From: Carolyn Nysingh
Sent: 07 August 2012 11:37
To: Nicola Spencer
Subject: FW: Request for comments - AL/72/12

This application is for a conversion of redundant farm building. A structural survey has been submitted. Can I have your observations please.

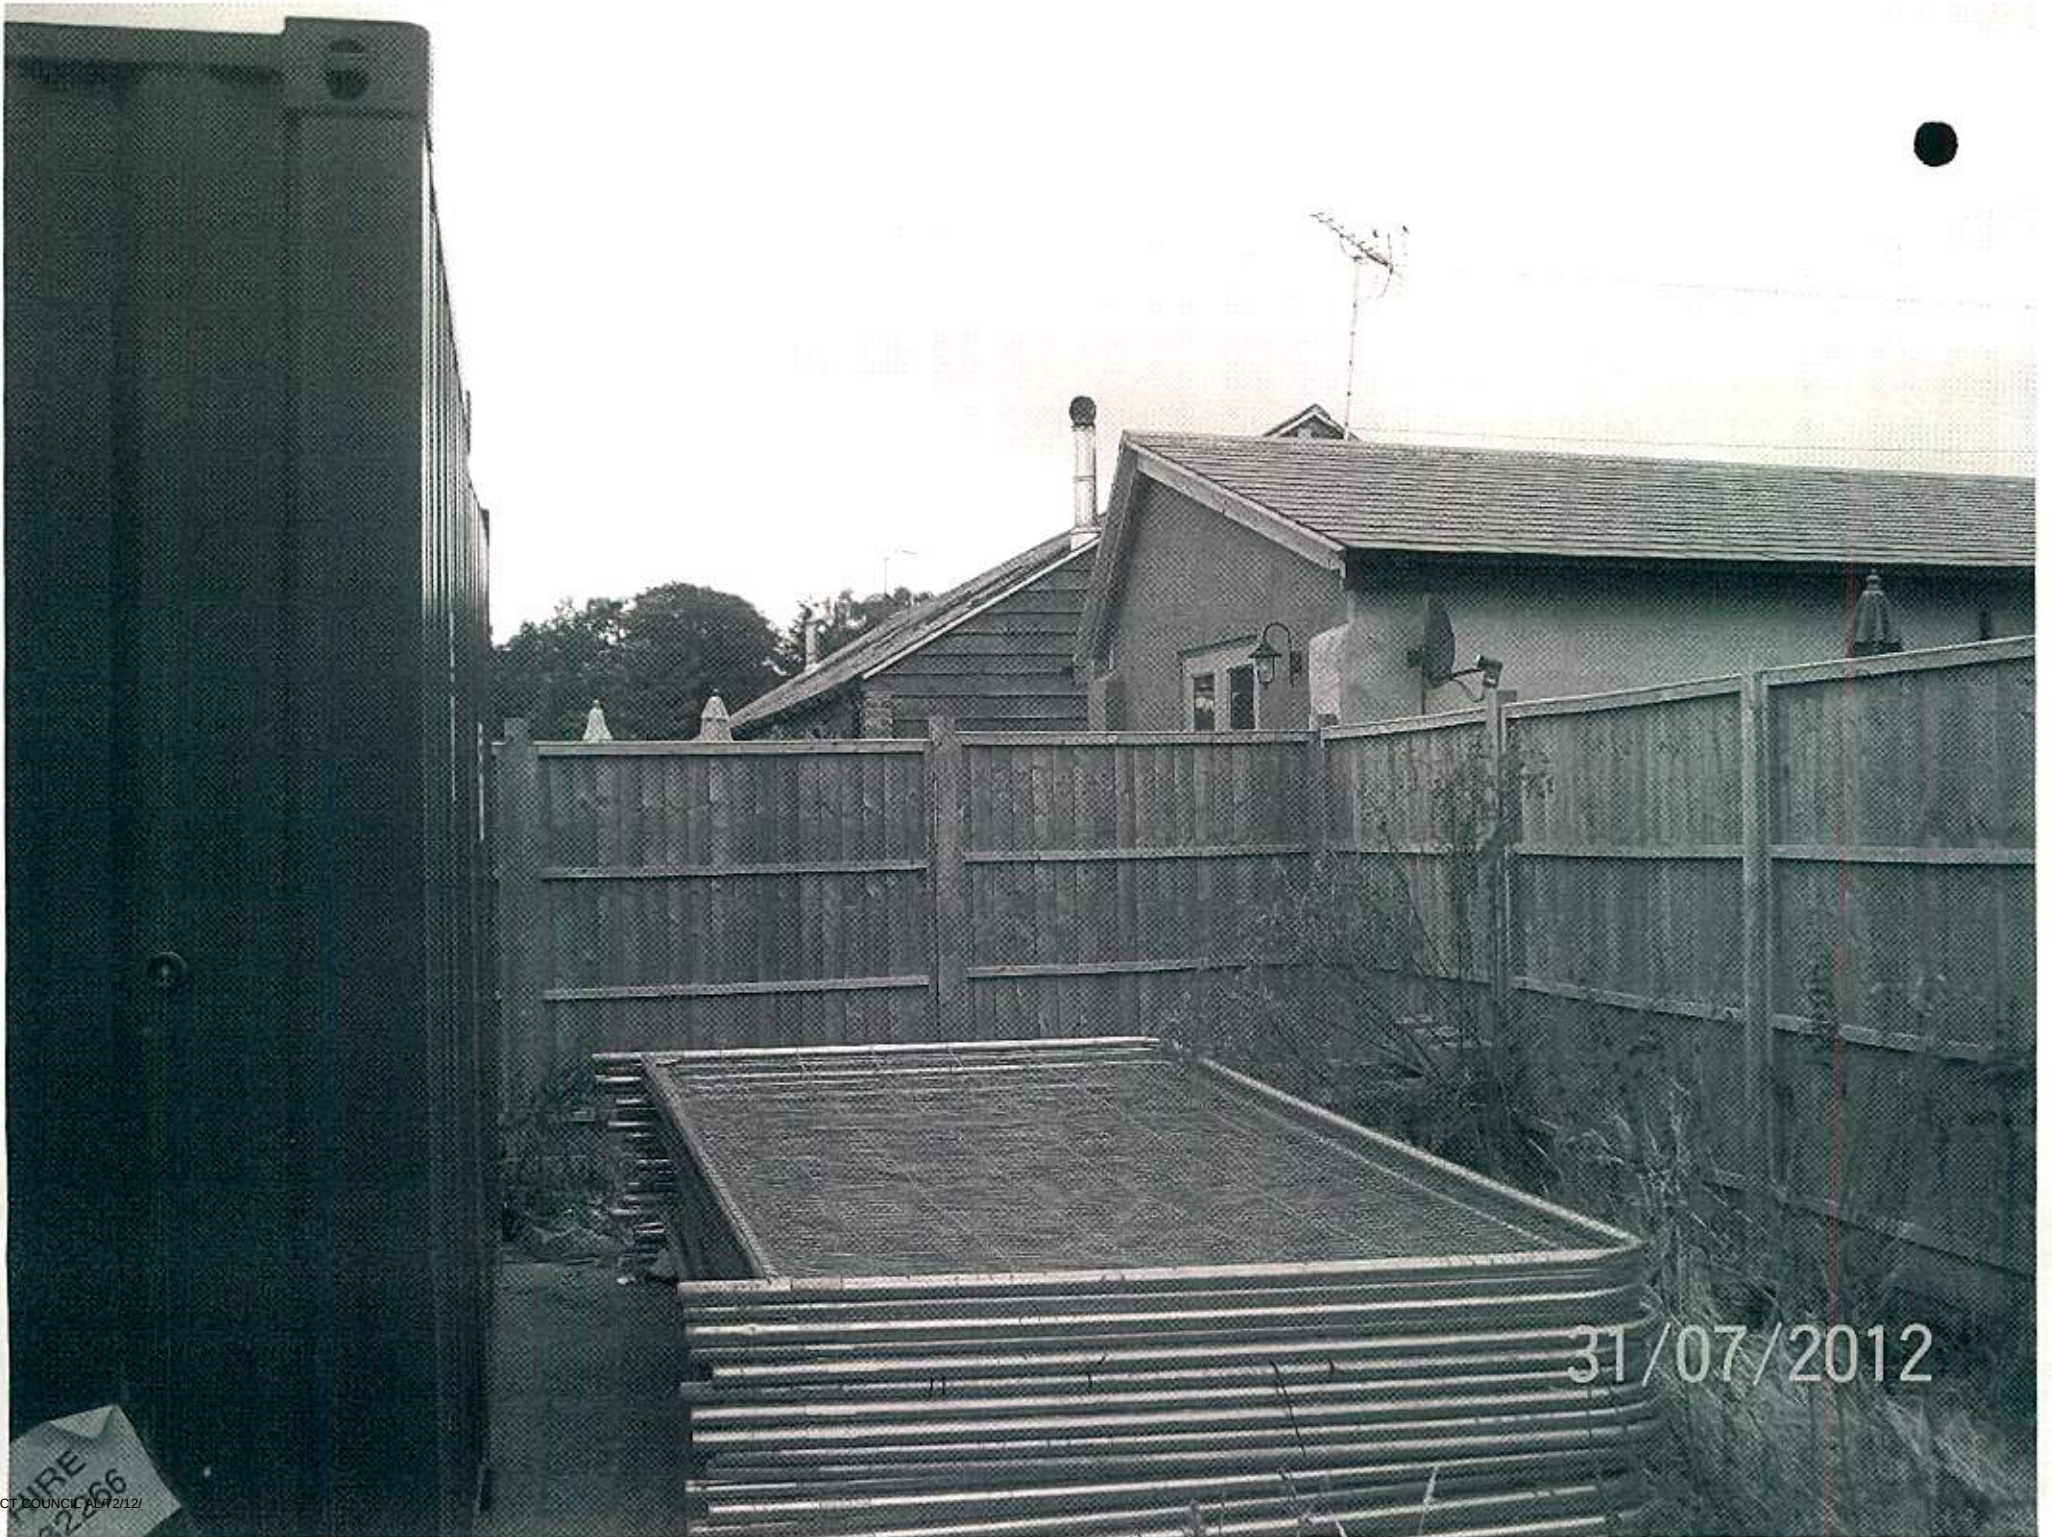
Having reviewed the latest structural report and compared it with the previous report it would seem that the majority of the structural defects have been rectified. In the report it notes that the stable doors have been retained but it doesn't mention if the doorways have been masonry filled. However the latest plans suggest that doorways are being filled with presumably full height windows and the stable doors being used as a shutter.

The internal wall arrangement differs from the original building and they no longer buttress the long south elevation. It must be demonstrated by investigation into the new wall construction that there are adequate and sufficient ties between the timber frame and masonry wall to show adequate buttressing/stability is provided especially the south elevation.
